Ribble Valley Borough Council
Church Walk,
Clitheroe,
BB7 2RA

Phone: 0300 123 6780
Email: lhscustomerservice@lancashire.gov.uk
Your ref:
Our ref: LHS/CS/3/2016/0577
Date: 21st July 2016

Proposal:	Proposed demolition of 14No. garages and erection of 4No. 3 bedroom dwellings (one pair of semi-detached and two detached) and alterations / improvements to existing vehicular access.
Location:	Land off Ribblesdale View Chatburn Clitheroe
Grid Ref:	377025 - 444190

SJ Bialecki Limited Building Surveyors
Drawing no 5052
Scale 1:100
Proposed Site Layout
Proposed Residential Development On Land At Ribblesdale View Chaburn

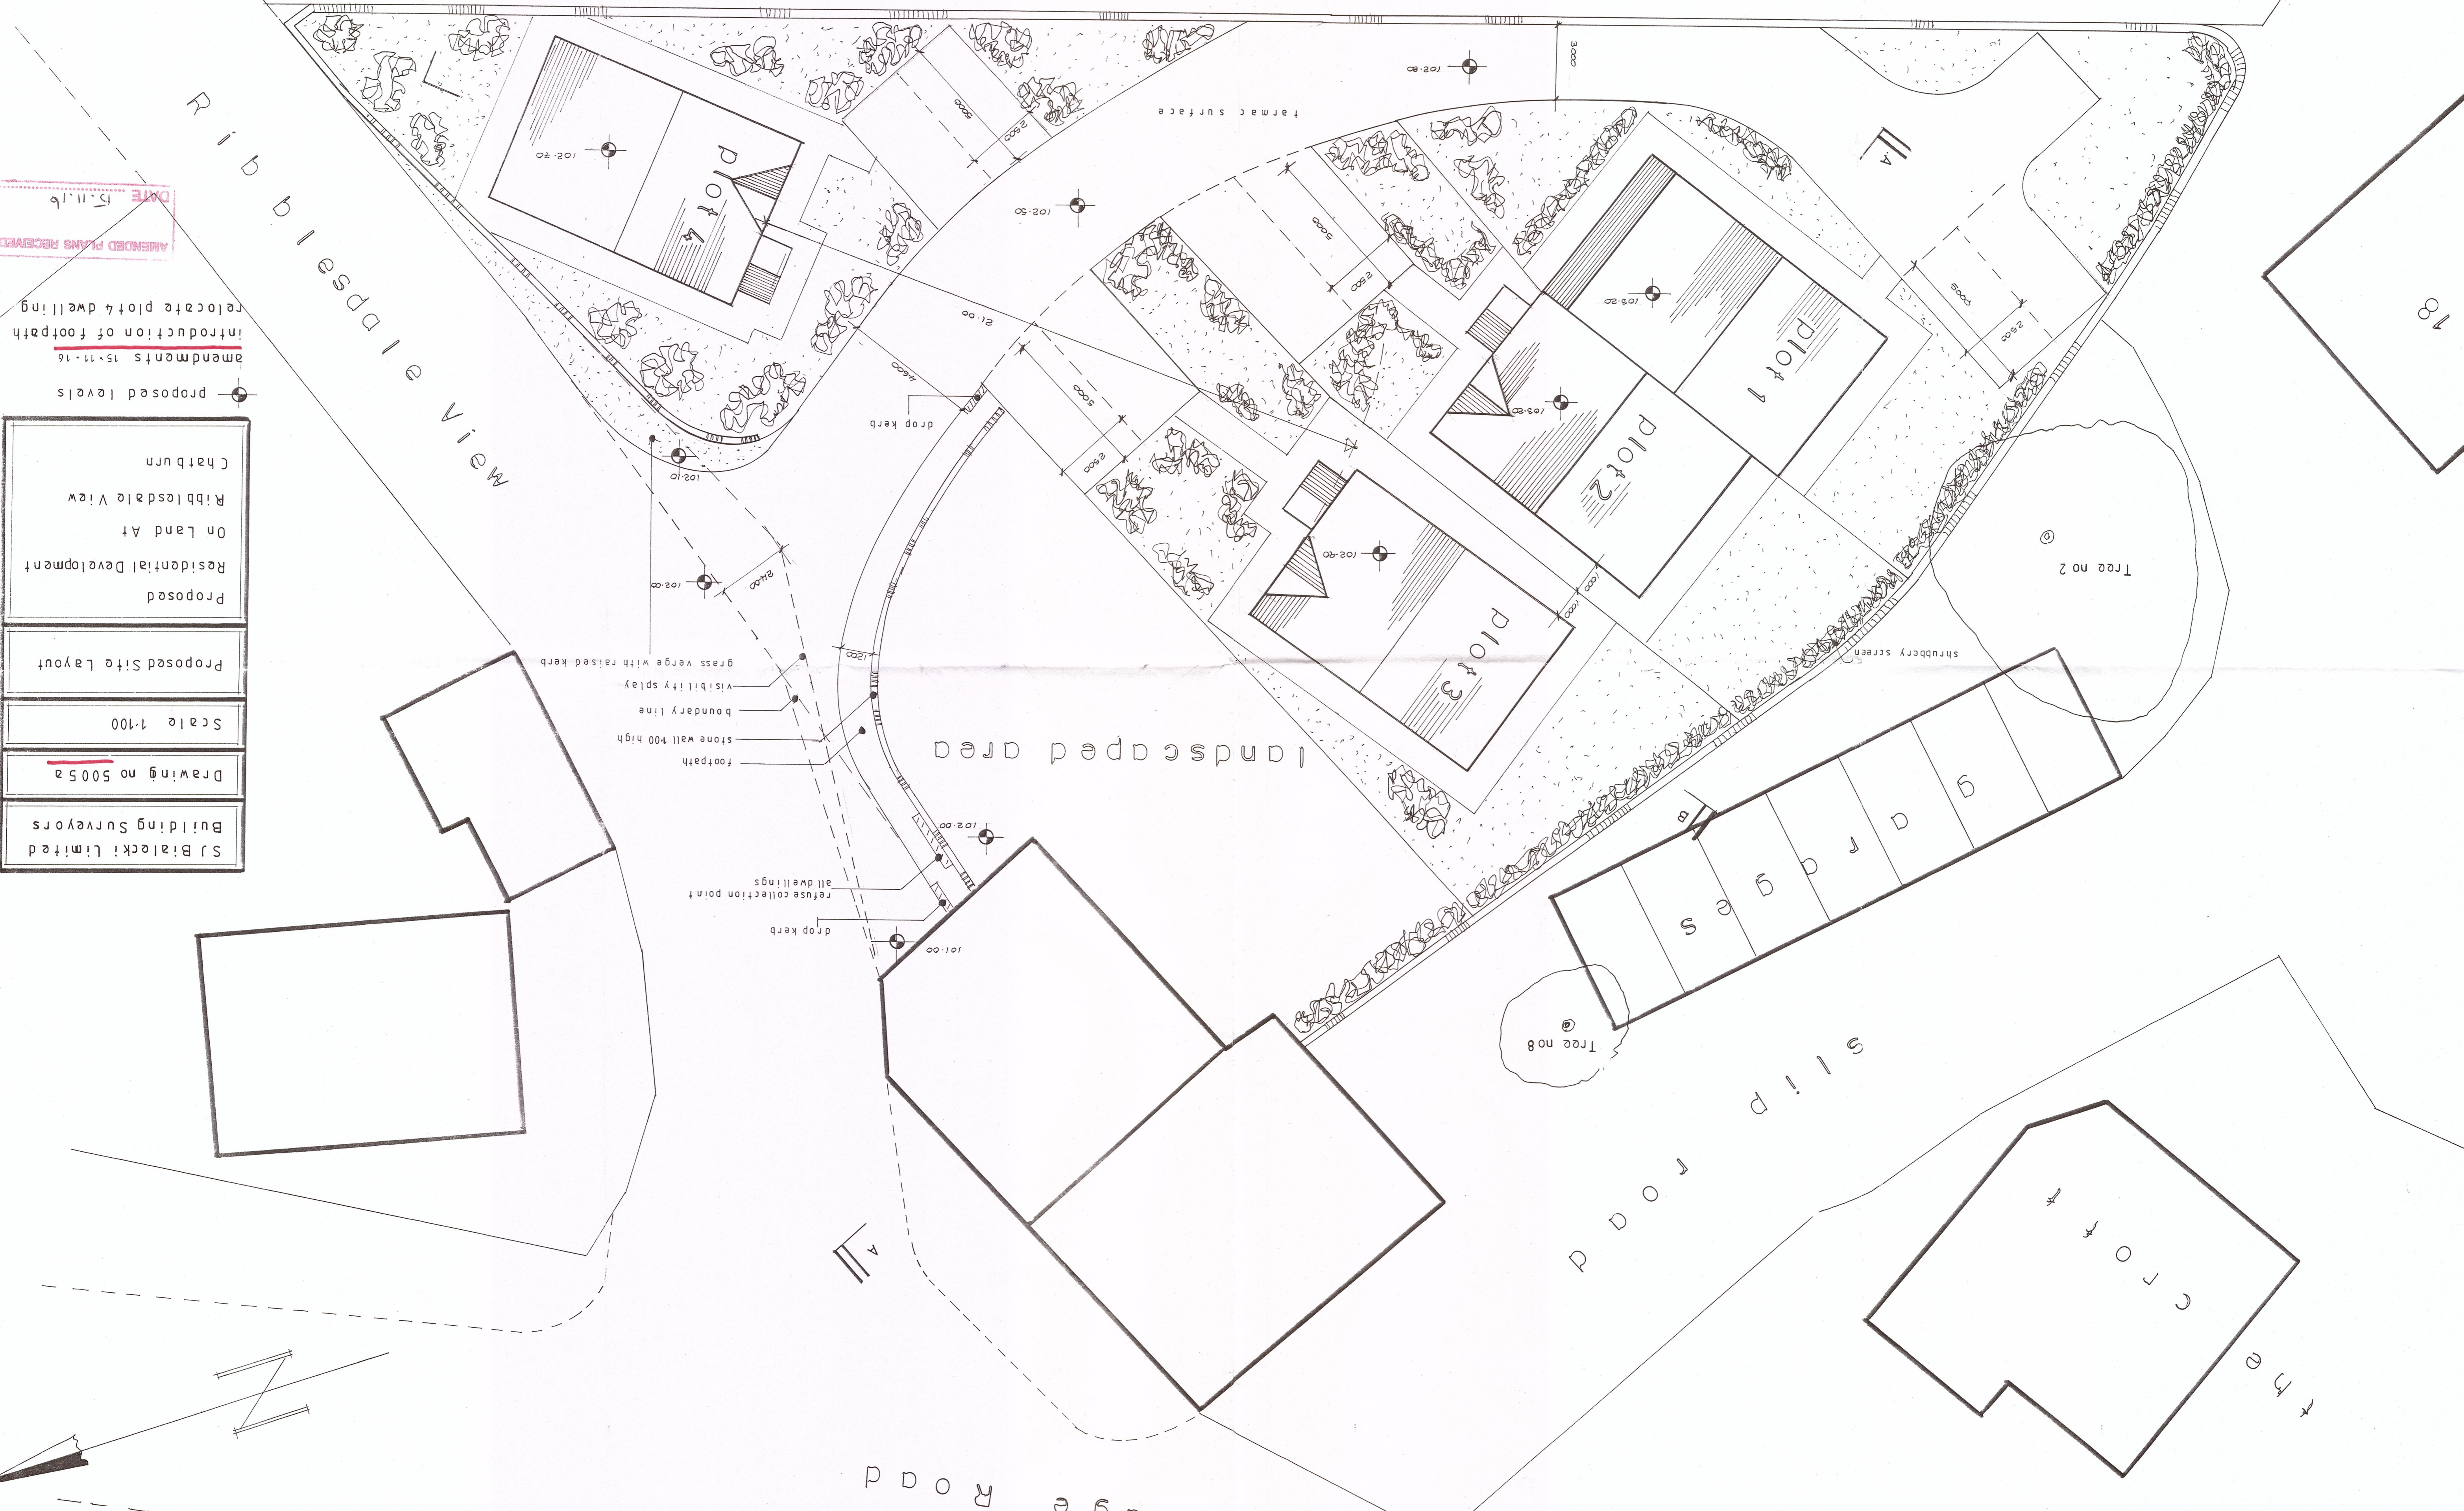
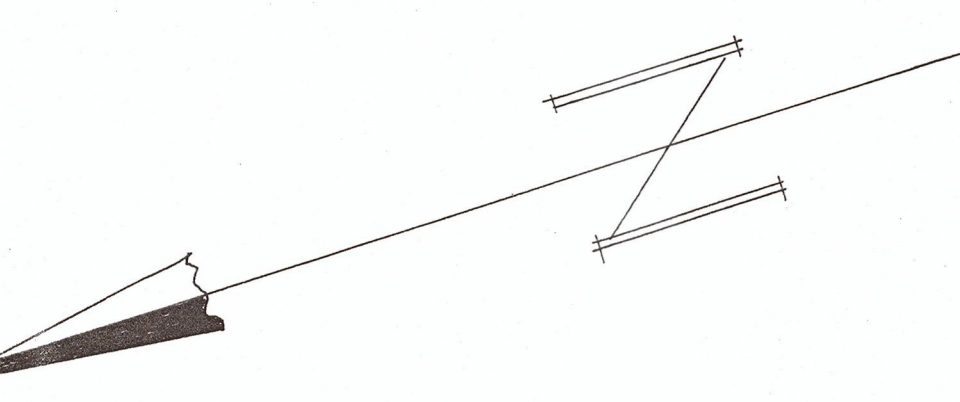
The Highway Development Control Section recommends a bin collection point is provided for plot 1 for the following reasons:-

The Highway Development Control Section recommends that the applicant provides a 450mm clearance between the new site access road and any stone wall to improve visibility at the site access and allow overhanging of the carriageway kerb.

S.J. Bialecki Limited Building Surveyors
Drawing no 5005
Scale 1:100
Proposed Site Layout
Proposed Residential Development On Land At Ribblesdale View Chatburn

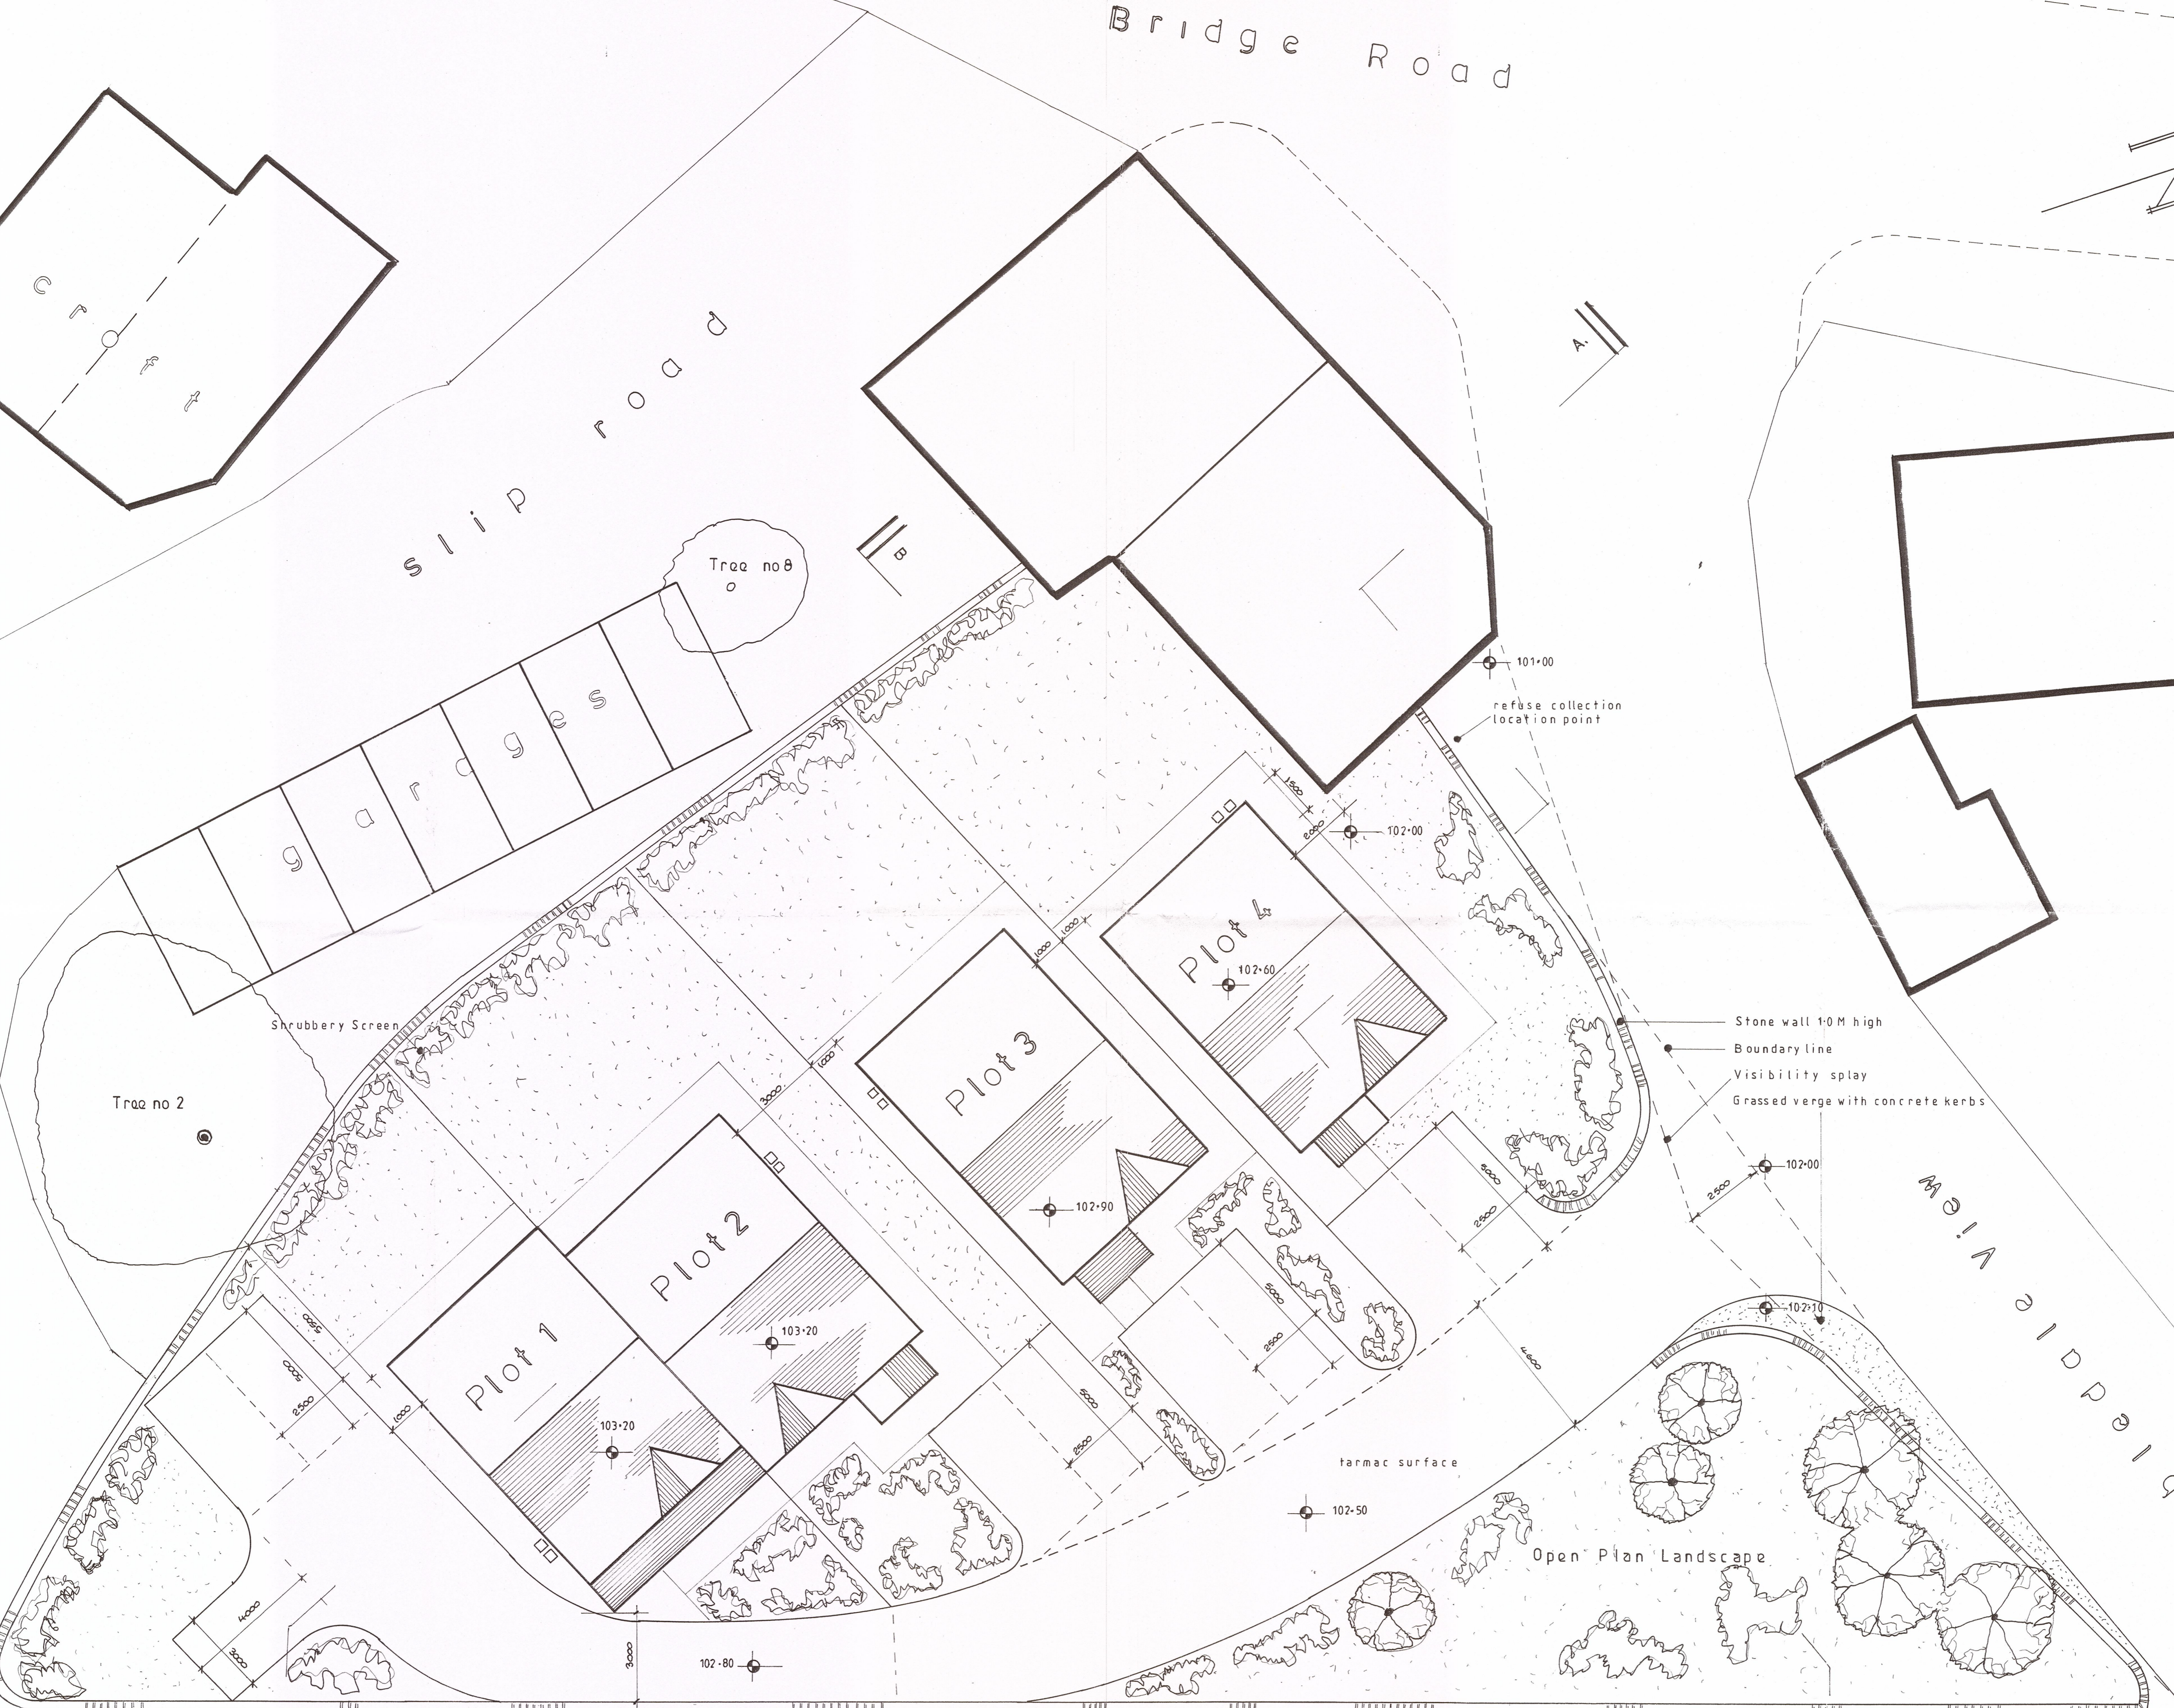
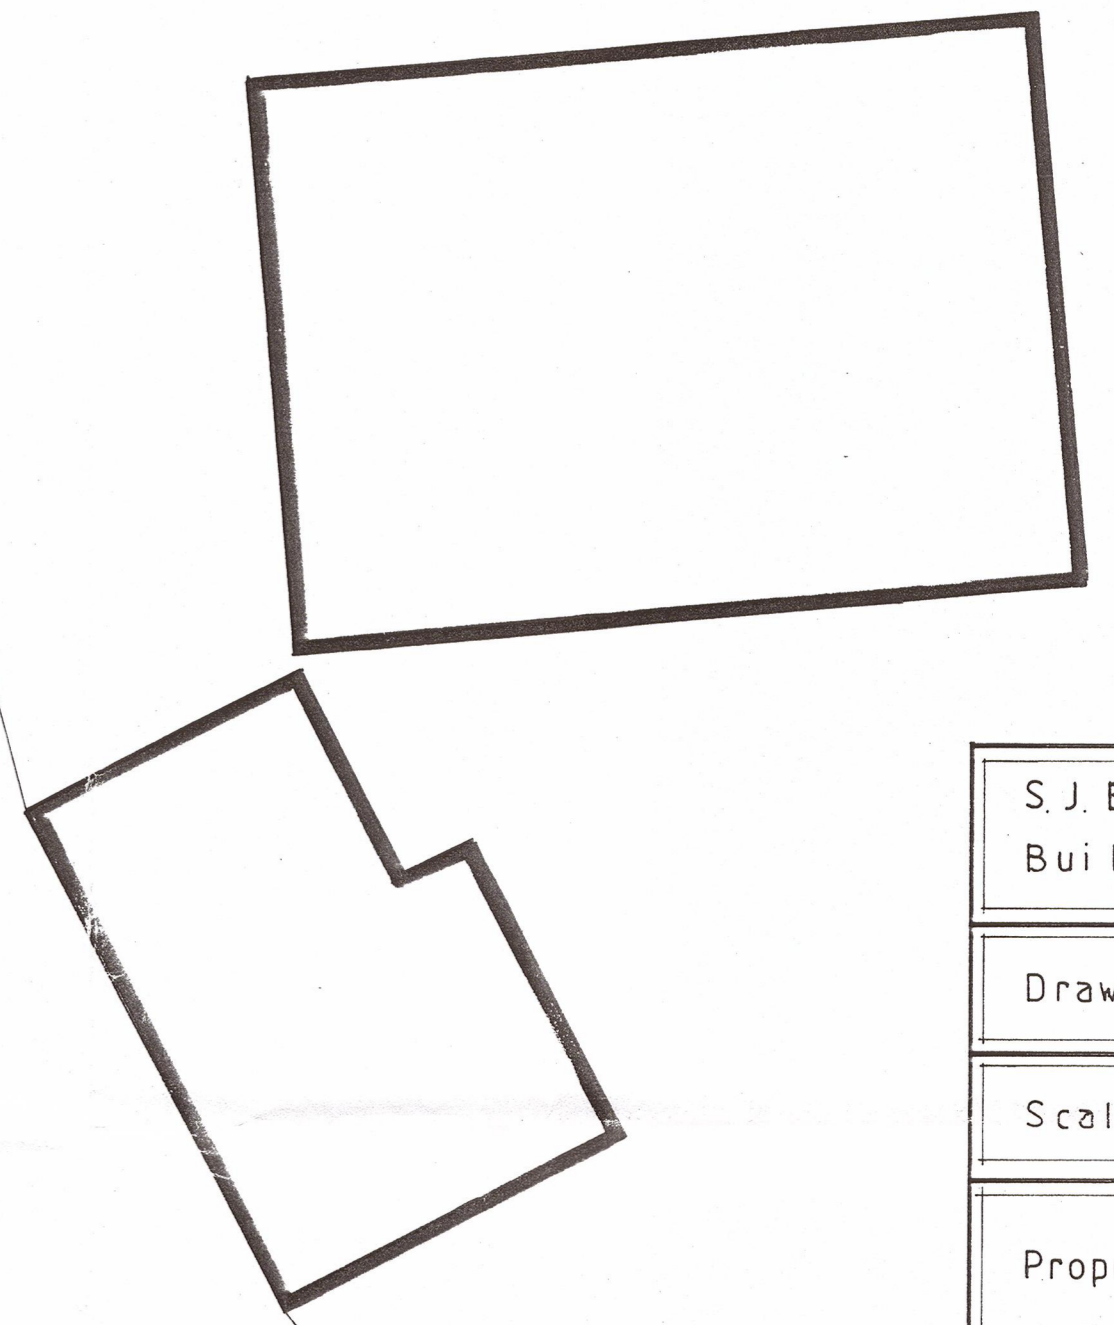
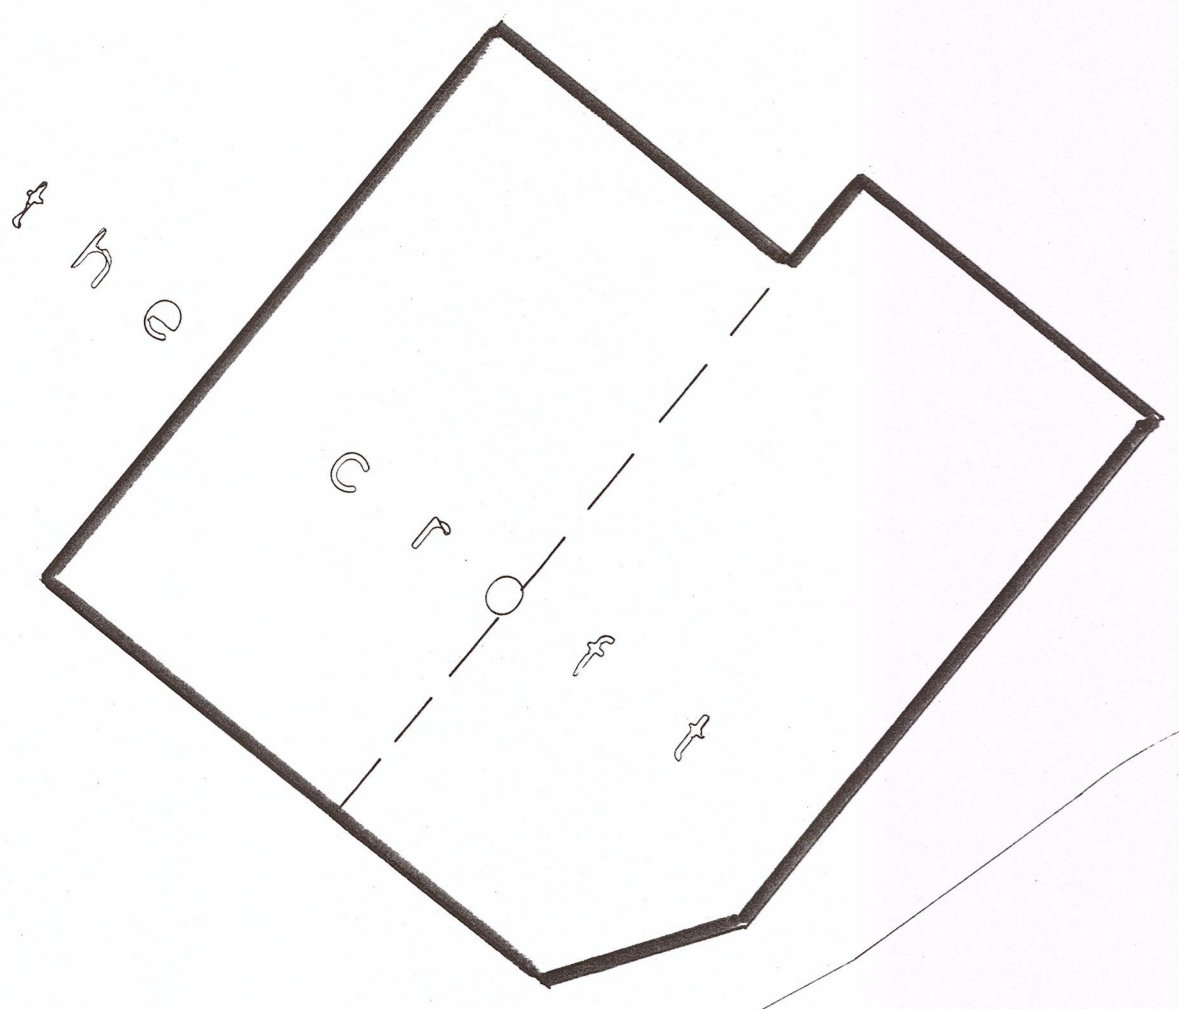
- 25m is the maximum distance a two wheeled refuse container is to be transported to the refuse wagon. From Manual for streets and BS5930: 2005.
- A resident should not be required to carry the waste more than 30m to the refuse storage point. From Manual for streets and BS5930: 2005.

The Highway Development Control Section is of the opinion that the available sight lines from the site access are acceptable providing the area of land between the stone wall and the edge of carriageway is kept clear of any obstruction higher than 1m.
